November 5, 2015

Harnett County Government Complex
307 W. Cornelius Harnett Boulevard
Lillington, NC 27546

RE: Harnett County Land Use Existing Tank Application # 15-5-37344

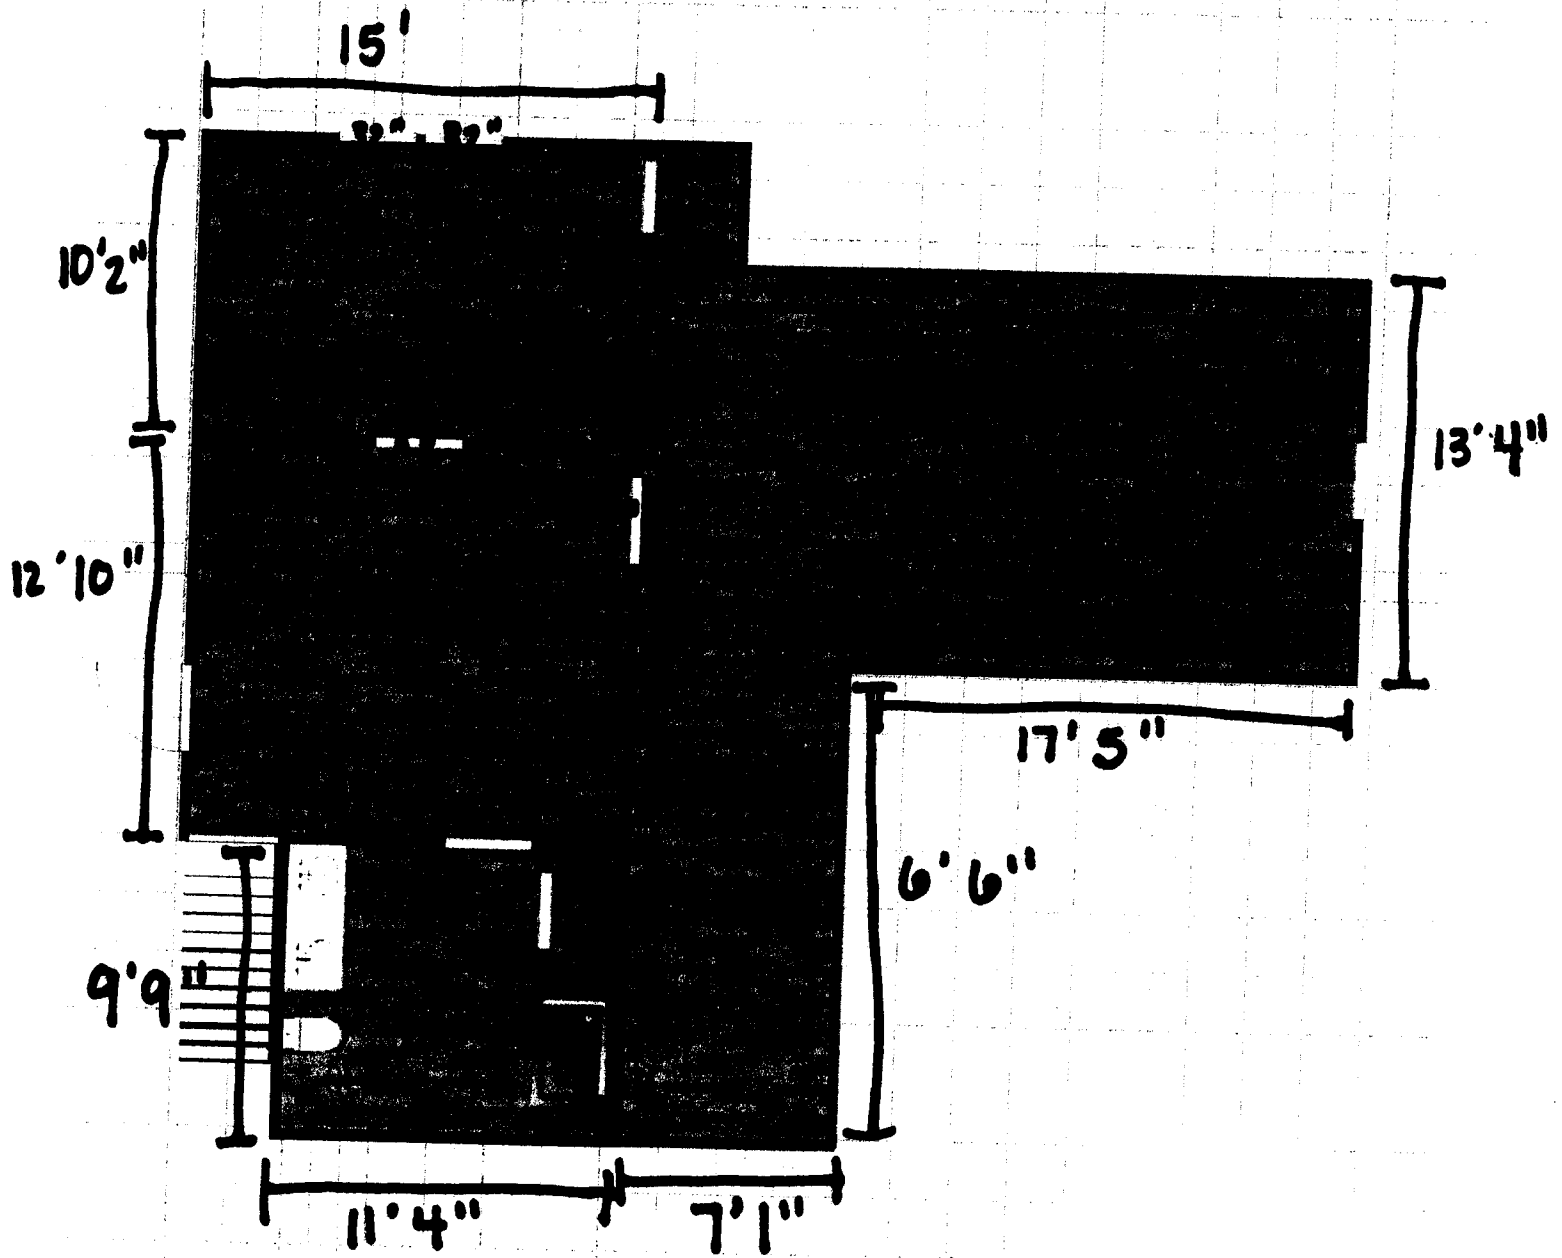
Based on the criteria set out in Title 15A, Subchapter 18A, of the North Carolina Administrative Code, Rules .1950, the evaluation indicated that the site is **UNSUITABLE** for the addition requested. Therefore, your request for an existing tank is **DENIED**. The site is denied based on the following:

- 15A NCAC 18A.1950a {16} - Any swimming pool must be 15' from any part of septic system.
- 15A NCAC 18.1945{b} - Each lot shall have original septic system plus repair area. (Not enough available space.)
- 15A NCAC 18A.1950 {10} - Any building to be 5' from septic tank and/or from drain line.
- 15A NCAC 18A.1950{c} - Nitrification fields and repair areas shall not be located under paved areas or areas subject to vehicular traffic.

Also the lid was not broken free (seal broken) Lift lid and set back down. You will need to contact a private consultant if you want to proceed. Call me to discuss further in detail. If you should have any questions or concerns I can be contacted Monday through Friday from 8am – 9am at 910-893-7547.
